Rezoning Transportation Analysis

Petition Number: #2022-032

Date	Description
07-26-22	First Review (PDM)
08-23-22	Second Review (WB)

**REZONING PETITION #2022-032**  
**SCHEMATIC SITE PLAN**

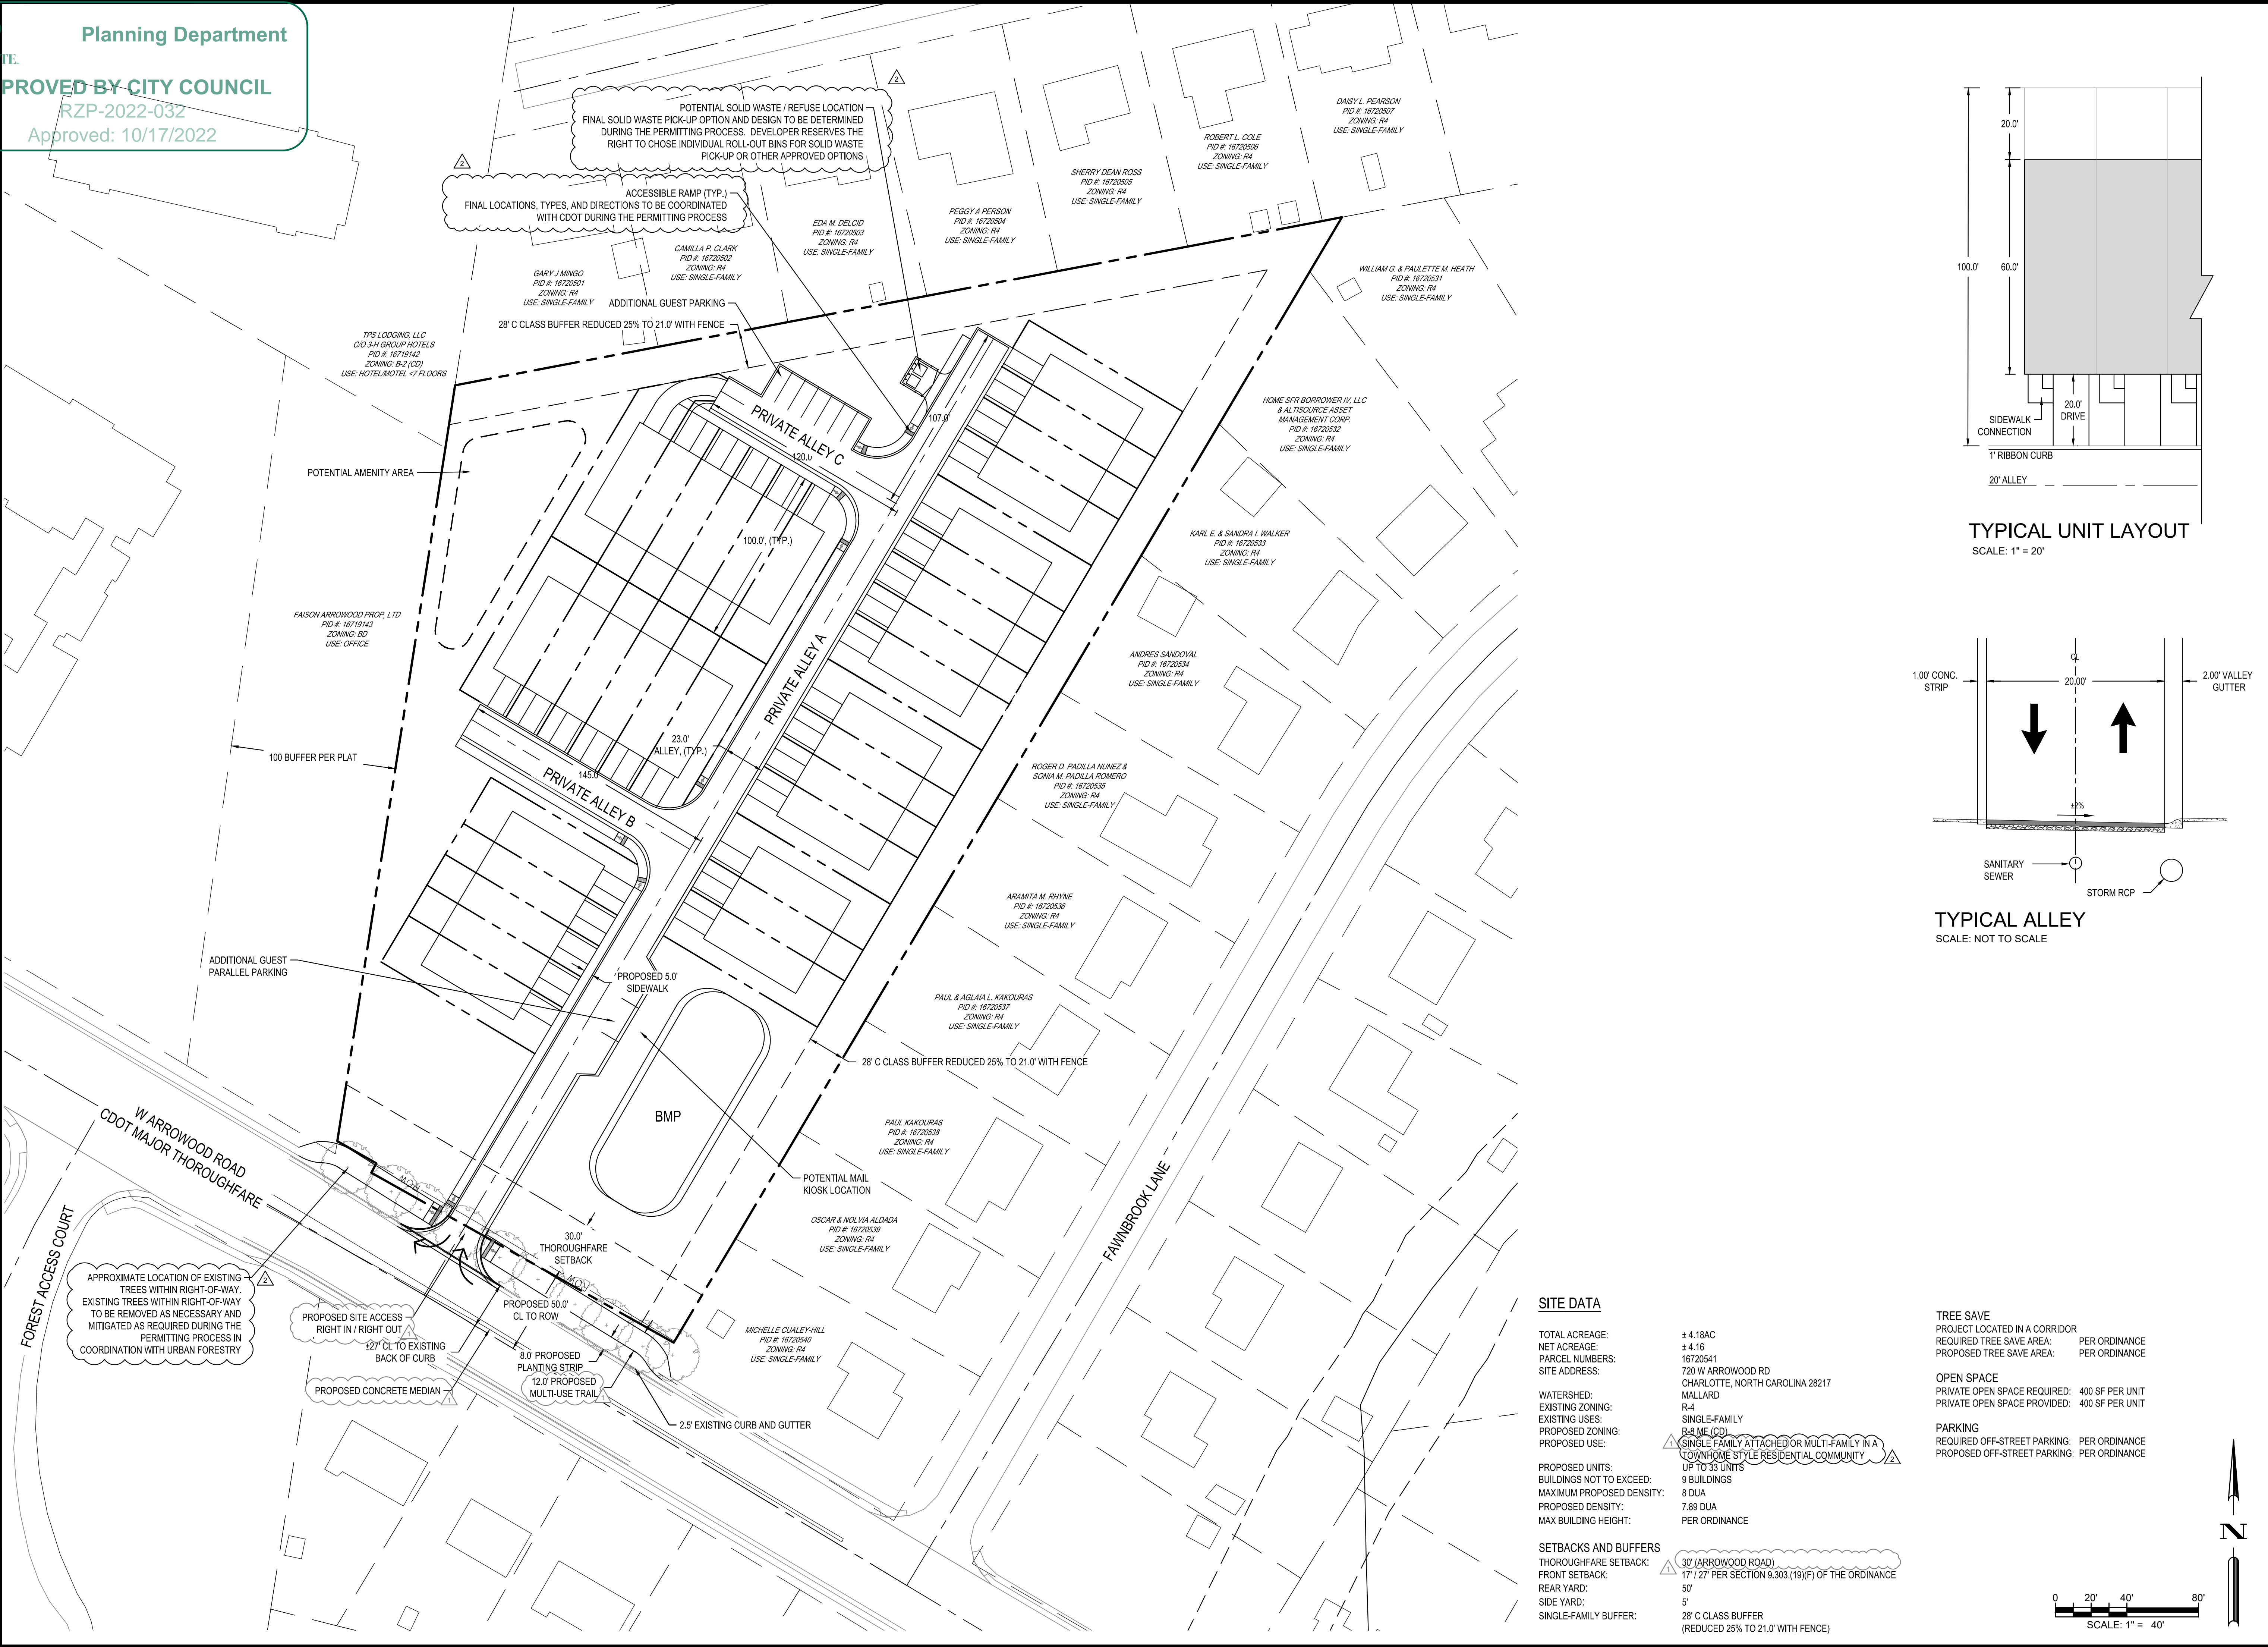
The petition is located adjacent to Arrowood Road, a city-maintained major thoroughfare and west of Fawnbrook Lane, a city-maintained minor collector. A Traffic Impact Study (TIS) is not needed for this site. Site plan revisions are needed to meet ordinance requirements and/or the outstanding items including revising the site plan to commit to installing ADA compliant ramps along internal streets. Further details are listed below.

1. **Curbline:** ~~The proposed zoning district has a setback measured from back of the existing or proposed future curblines.~~
 - a. ~~**W Arrowood Road:** The future location of curb and gutter is in its existing location.~~

~~Label and dimension the curb and gutter from the centerline for each road on the site plan.~~

3. ~~Site plan and conditional note(s) revisions are needed to commit to installing a 12' multi-use path along Arrowood Road to meet the City Charlotte BIKES Policy.~~

4. ~~Revise site plan to dedicate 50 feet of right of way from the Arrowood Road centerline if it does not exist. The site plan shall label and dimension the right of way from the road centerline. Ensure a continuous 50ft ROW is provide at a minimum for the full length of the site.~~

5. ~~Add conditional note stating, "Intersection sight distance will be met per CDOT's Sight Distance Policy, dated May 2003, at the intersection of Arrowood Road and the proposed private street." Proposed private street off Arrowood Road may be subject to relocation if intersection sight distance cannot be achieved.~~

6. ~~Site plan and conditional note(s) revisions are needed commit to installing a required Left Turn Lane into the site on Arrowood Road into the site. label and dimension left turn lane on site plan and add conditional note describing all turn lane design requirements. The existing left turn lane should be restriped to accommodate the new street. **Comment Rescinded (8/23/2022) – Access will be limited to a right-in and right-out condition.**~~

7. ~~Site plan and conditional note(s) revisions are needed to commit to extending the proposed sidewalk and ADA compliant sidewalk ramps closer to the intersection of Private Alley B.~~
